Thankyou for the consultation. The comments of the **Arun District Conservation Area Advisory Panel** are as follows:

Application No: Y/10/22/PL

Site Address: Land to the south of Ford Lane and east of North End Road Yapton BN18 0DS

Description of Works: Erection of 15 No dwellings (including 4 No affordable units) with associated access, parking, landscaping, drainage and public open space (additional units to those approved under application Y/123/21/PL). This application may affect the setting of a listed building, affects the character & appearance of the

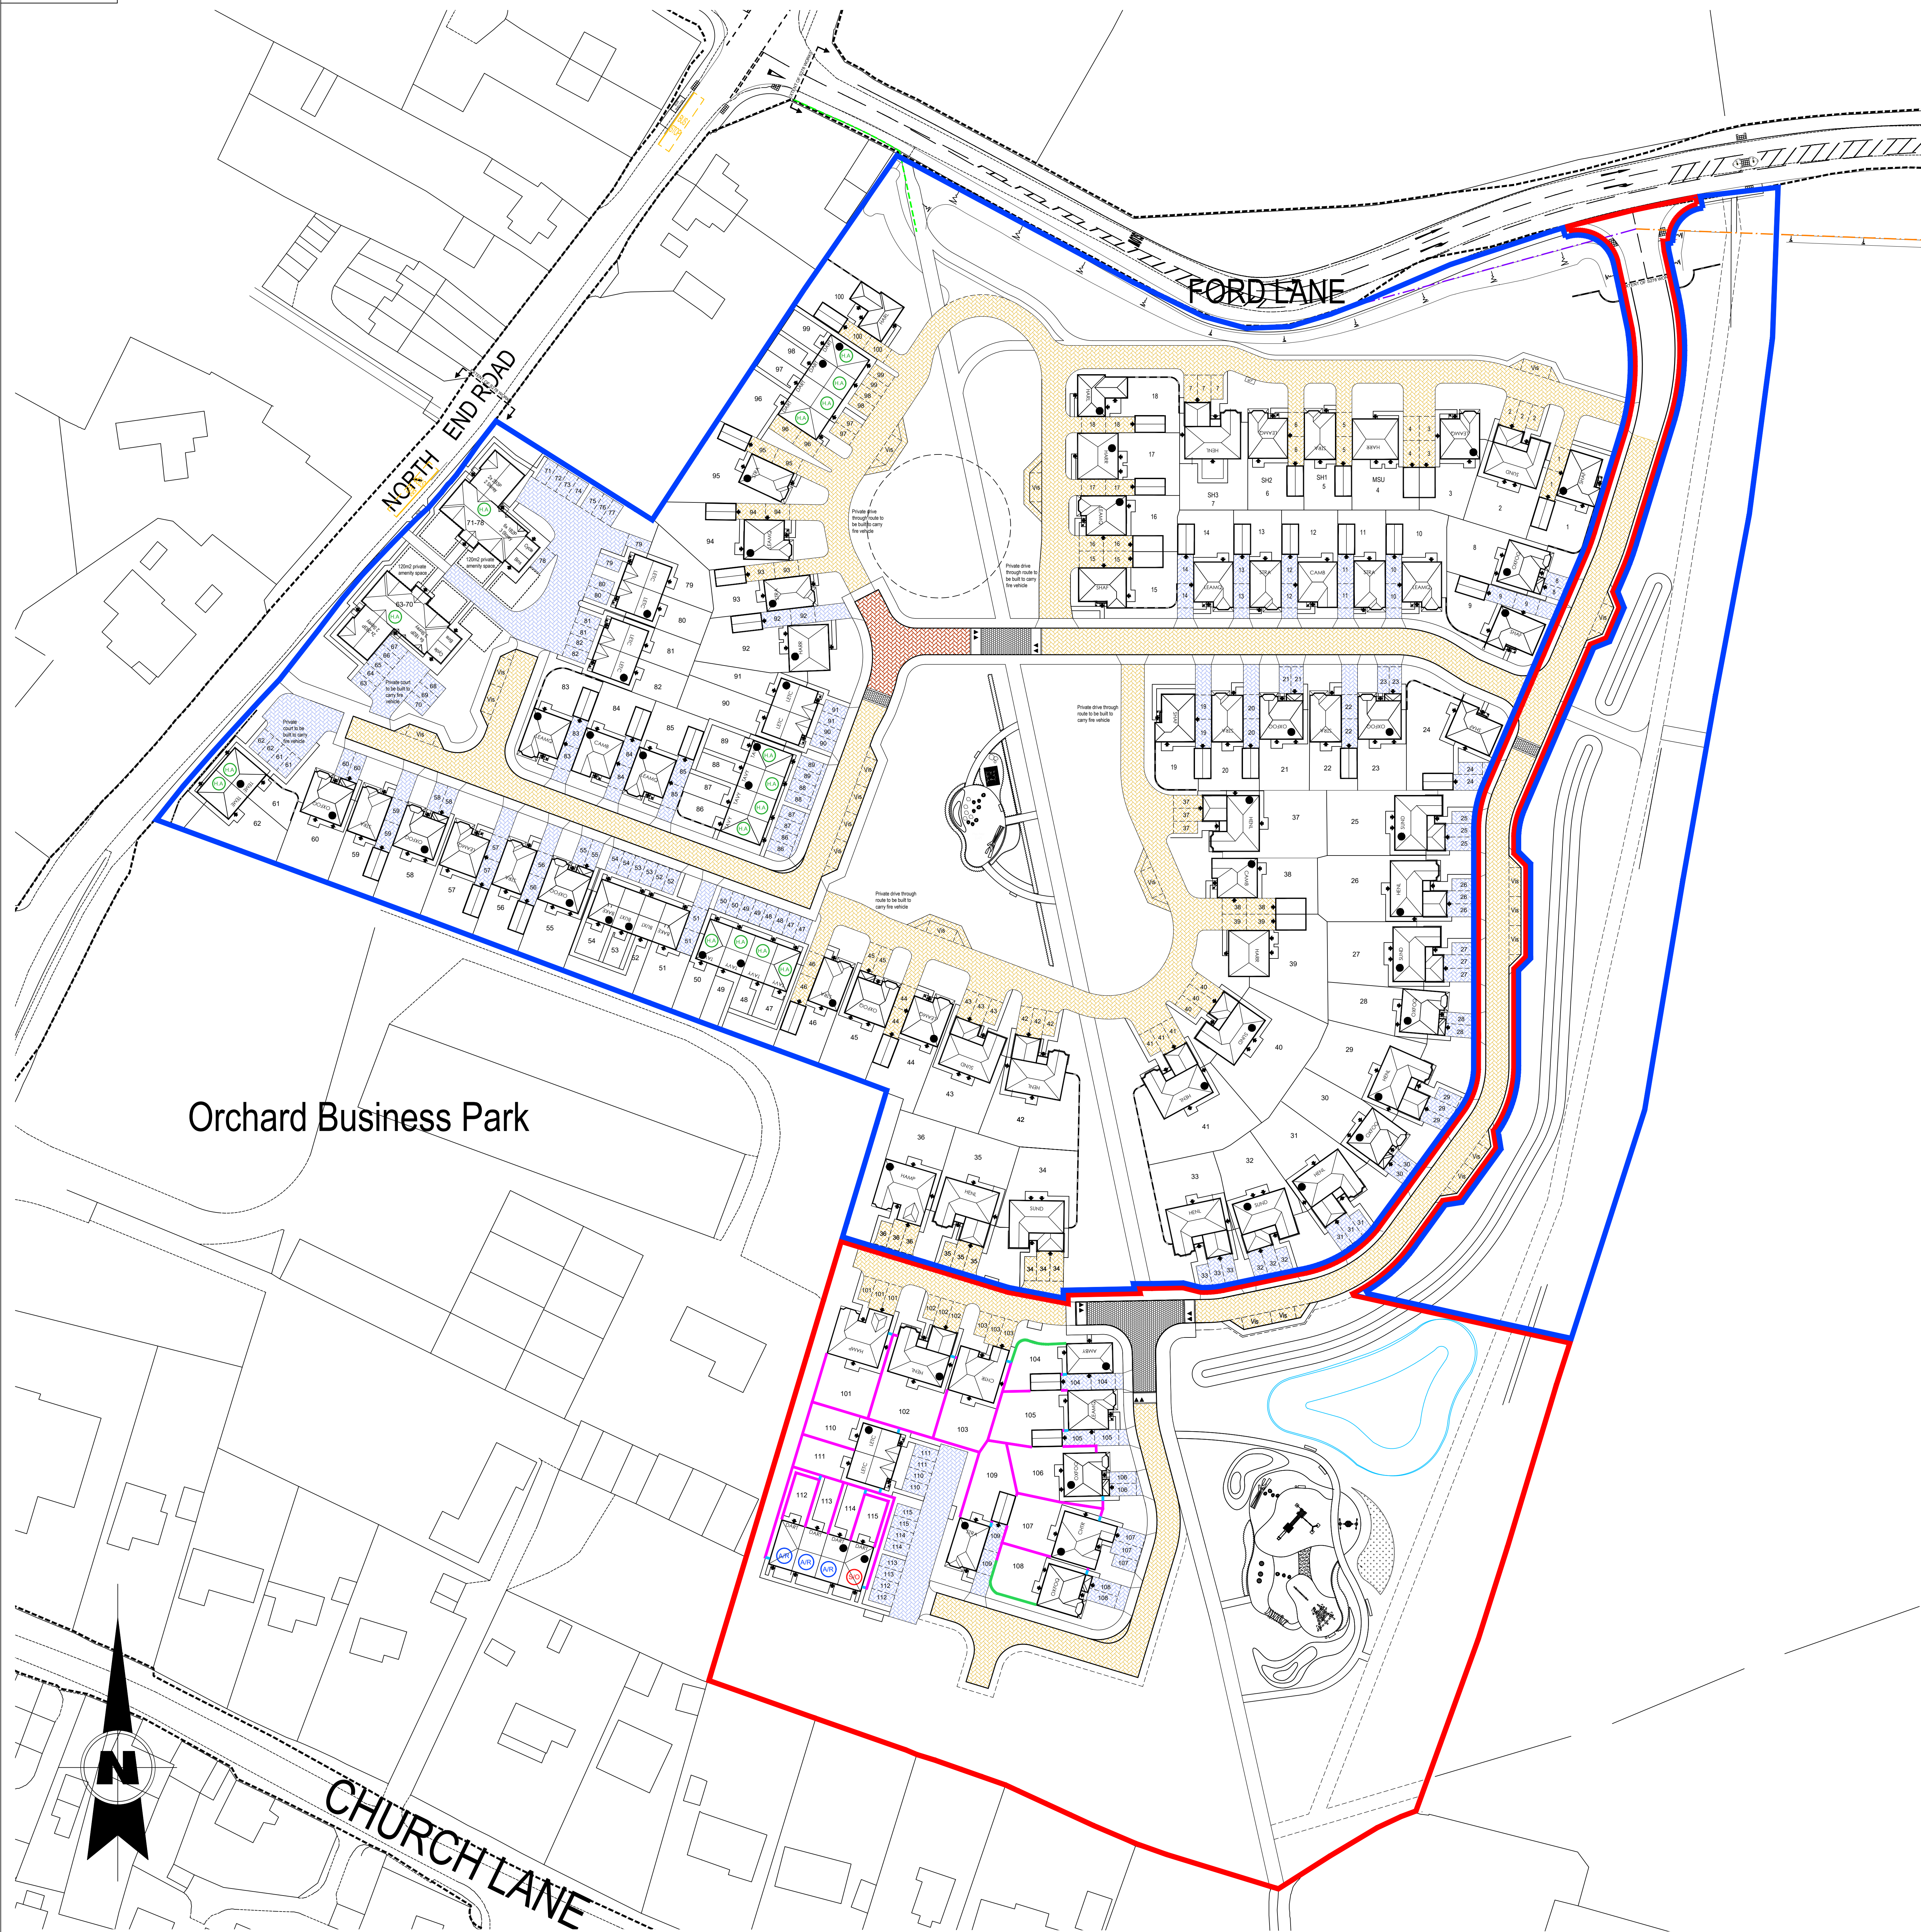
The proposal represents a major incursion into, and therefore a significant reduction in size of, the area intended for open space located on the northern edge of the Church Lane, Yapton, Conservation Area, as indicated in the previous planning approval and permission (Y/82/20/RES and Y/123/21/PL).

Given the rural nature, character and origins of the conservation area, the size and extent of the previously agreed open space was important in order to retain the essence of that character as viewed in the approach into and out of village from the public footpath which crosses the Ford Lane development site. That quality will now be diminished and compromised by the proposed development and will adversely affect the setting of the conservation area.

The current proposals to encroach on the previously agreed area of open space will impact adversely on the setting of the conservation area. In addition, the house designs and layout proposed pay absolutely no regard to the particular character, appearance or significance of the conservation area and are totally unsuitable and inappropriate.

Title:
MASSING PLAN

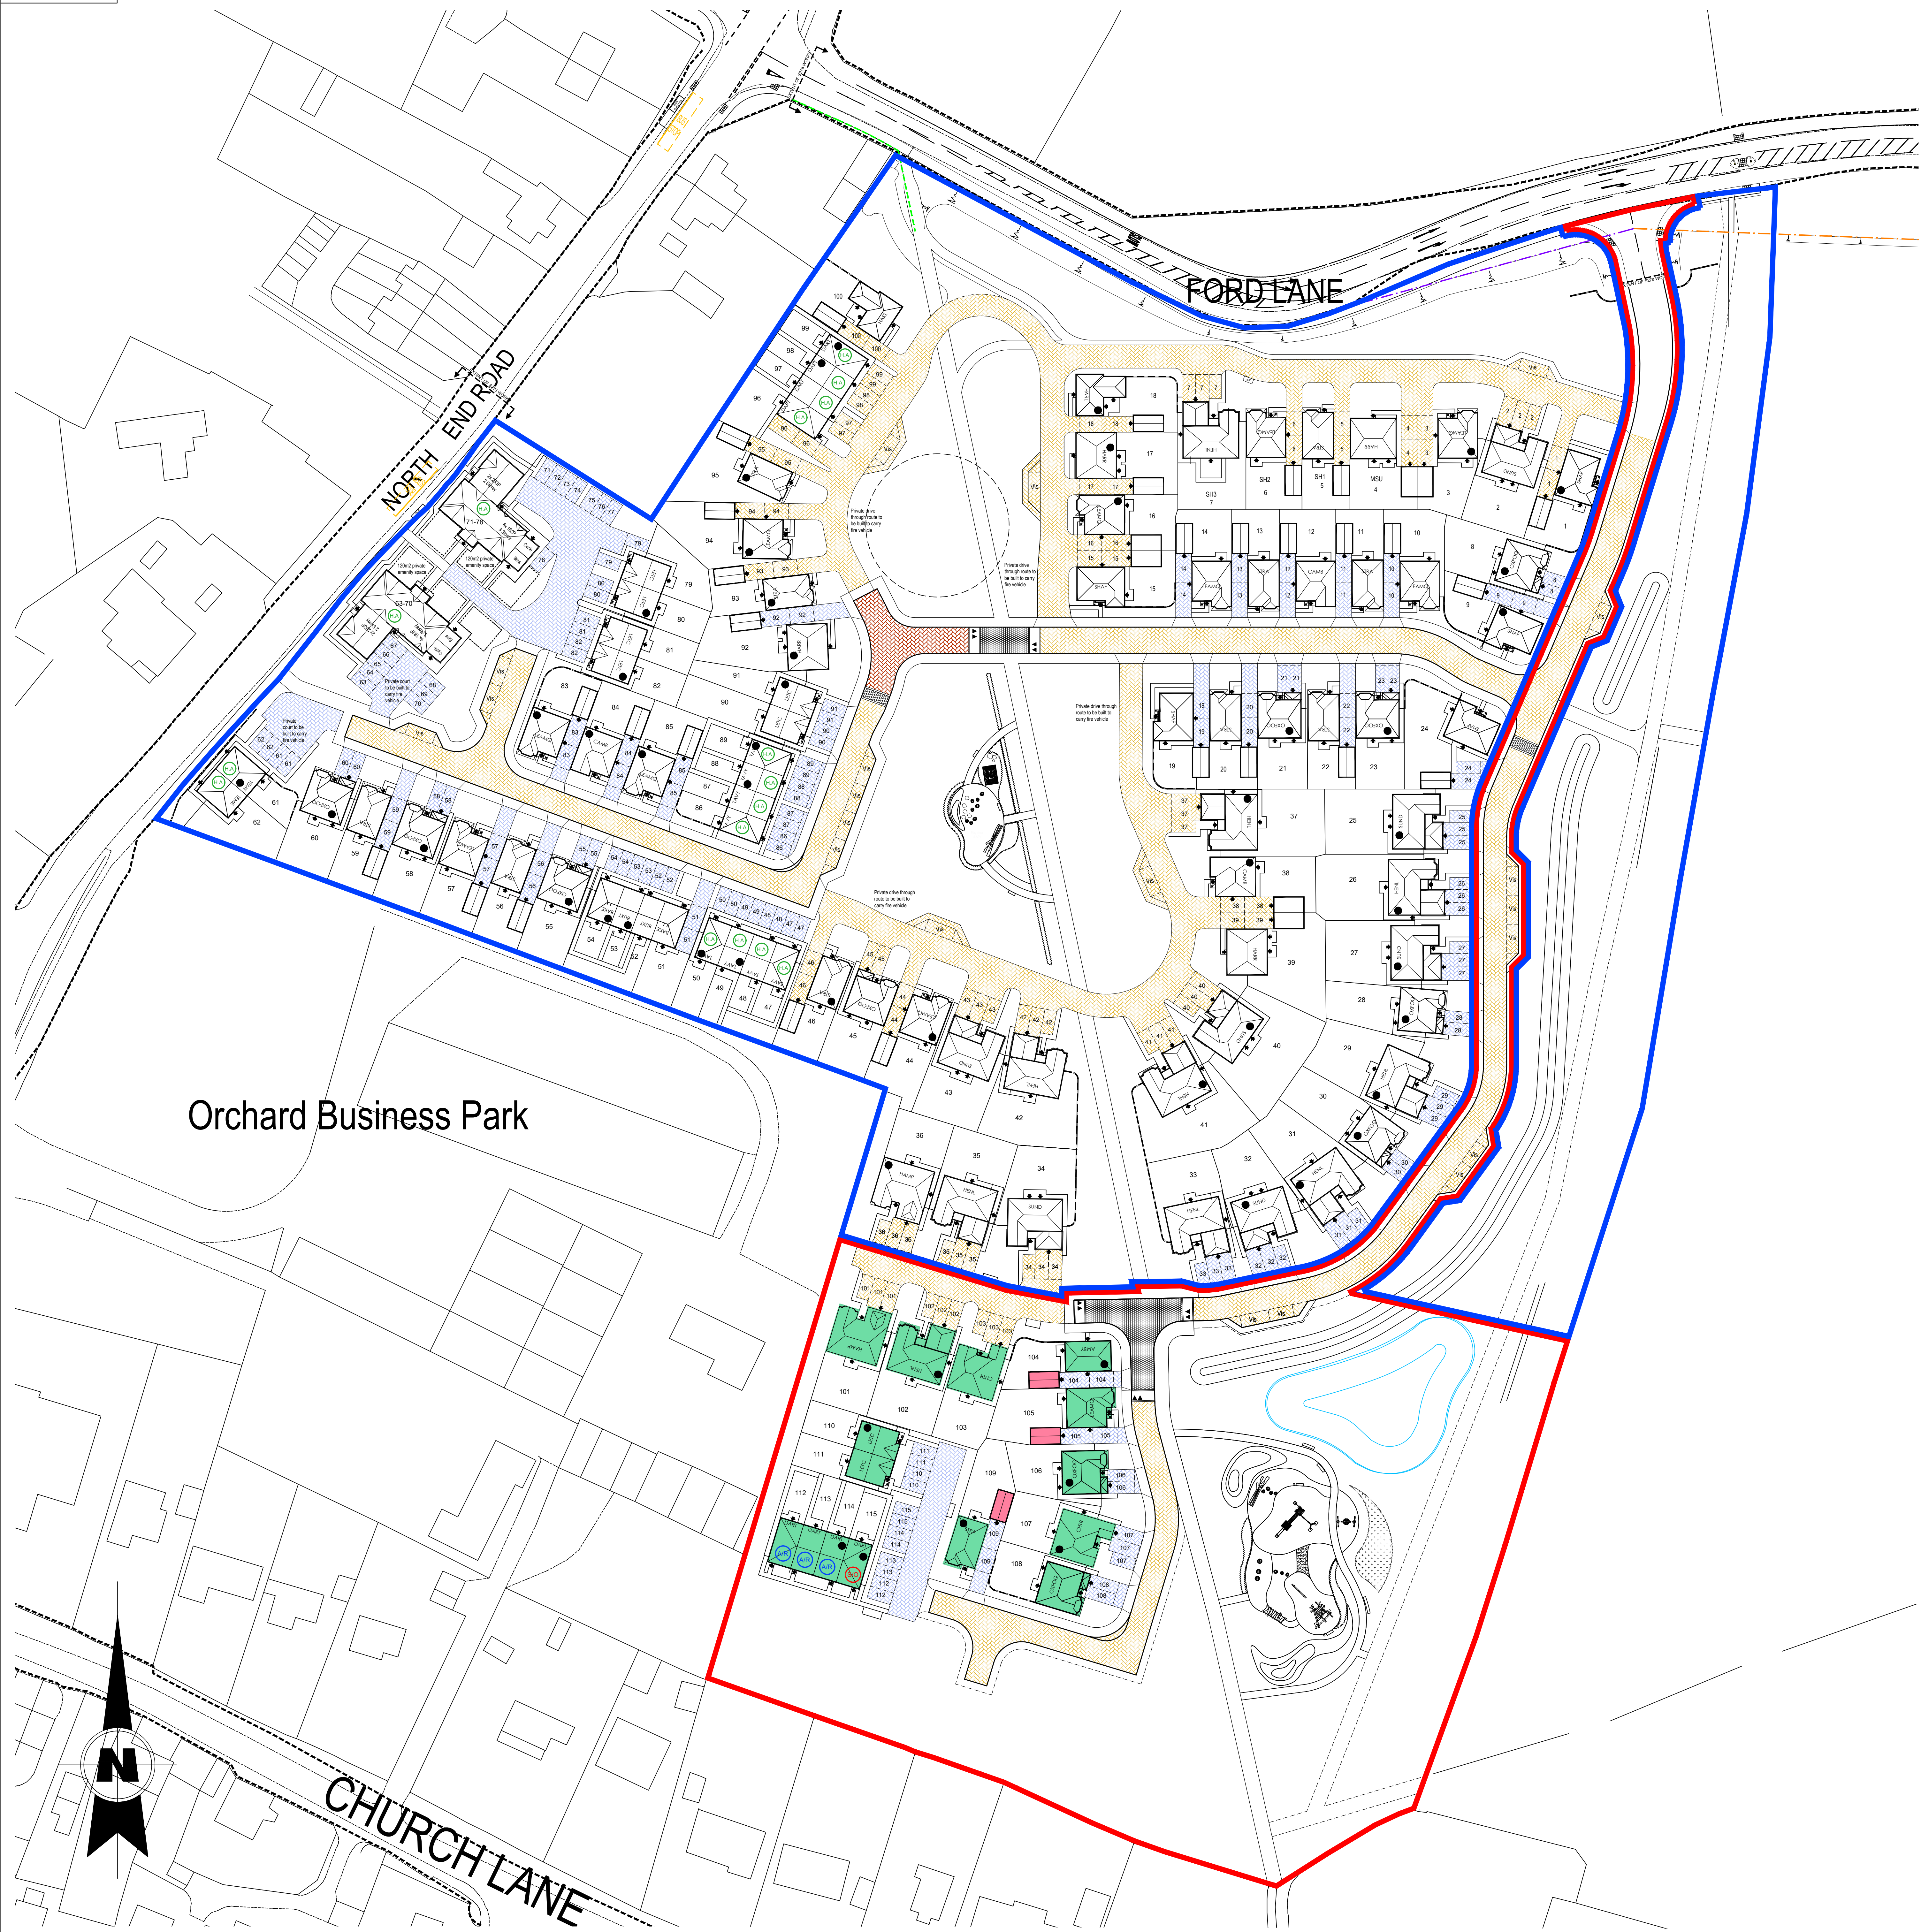
The detriment is made even worse by the suburban, 'anywhere', standard, mass housing developer, concrete interlocking tile roofed, and estate like house designs proposed in the application. If development is to take place in

this very sensitive location; essentially a rural edge to the conservation area, then it requires a much more appropriate, carefully considered and non-standard, one-off solution to housing design, form, massing, details and materials. A standard housing estate layout is also totally inappropriate.
